GATWICK AIRPORT NORTHERN RUNWAY PROJECT

Planning Inspectorate's Reference: TR020005

Issue Specific Hearing 6: Climate Change and Greenhouse Gas Emissions

Post-Hearing Submission

Diagram 16.9.3: Comparison of Project Aviation Emissions with Jet Zero Residual Emissions Trajectory

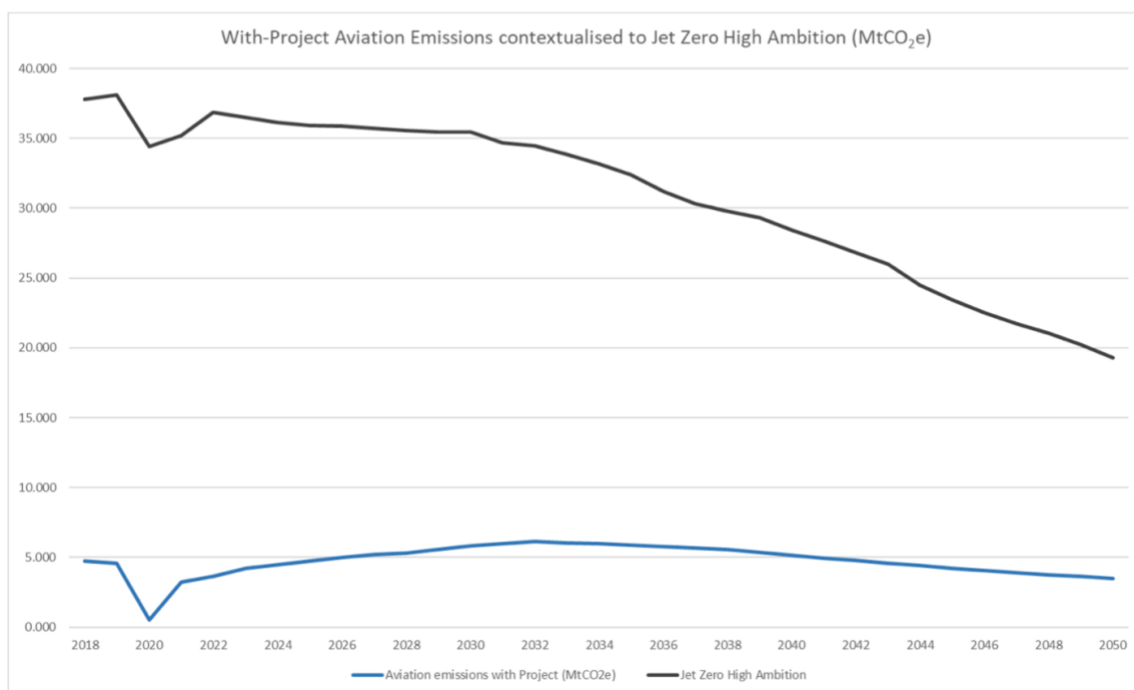
<ul style="list-style-type: none">• The Authorities would therefore welcome confirmation from the Applicant as to whether the higher line in diagram 16.9.3 [APP-041, page 63] is showing Jet Zero (2022) or Jet Zero: One Year On (2023).• In relation to diagram 16.9.3, the Authorities would secondly welcome confirmation from the Applicant as to whether the aviation emissions from the Application include a whole life cycle assessment.• Even taking the figures in this diagram at face value, the diagram does not tell us what proportion of the Jet Zero budget the Application would account for. Looking at the diagrams crudely, one might consider that this is in the region of 15% to 20%. It would therefore be helpful if the Applicant could provide the figures so that we can actually see where this sits and the implications for the issue of the significance of the NRP project's emissions, as summarised above. <p><u>Whole-Life Carbon Assessments</u></p> <ul style="list-style-type: none">• The Legal Partnership Authorities note from the most recent National Networks NPS that whole-life cycle carbon assessments are not inconsistent with national budgets and the UK's carbon budgets as the Networks NPS now expects whole-life carbon assessments to take place.• In Chapter 16 of the Applicant's ES [APP-041], we observe that there are references to documents which might include whole-life carbon assessment as part of their methodologies; however, it is not clear to us whether those assessments have been applied by the Applicant thus far.• It is currently unclear whether the Applicant's approach is consistent with a whole-life carbon assessment and, if not, whether the applicant is proposing, particularly in the light of the revised National Networks NPS to provide further information on this issue.• The Legal Partnership Authorities consider that the Applicant's approach to this issue will have a key bearing on the assessment of significance of the result which are presented. <p><u>Environmentally Managed Growth</u></p> <ul style="list-style-type: none">• For clarity, the ExA should note that the Legal Partnership Authorities' calls for the Applicant to adopt an Environmentally Managed Growth approach to the NRP are primarily driven by concerns relating to the local environmental impacts (noise, air quality, traffic, greenhouse gas emissions) of the project, rather than its implications for carbon budgets and targets.• As explained in the Legal Partnership Authorities other submissions, the Environmentally Managed Growth approach would tie the achievement of growth to both mitigation measures which offset undue impacts of that growth and the claimed benefits of that growth.
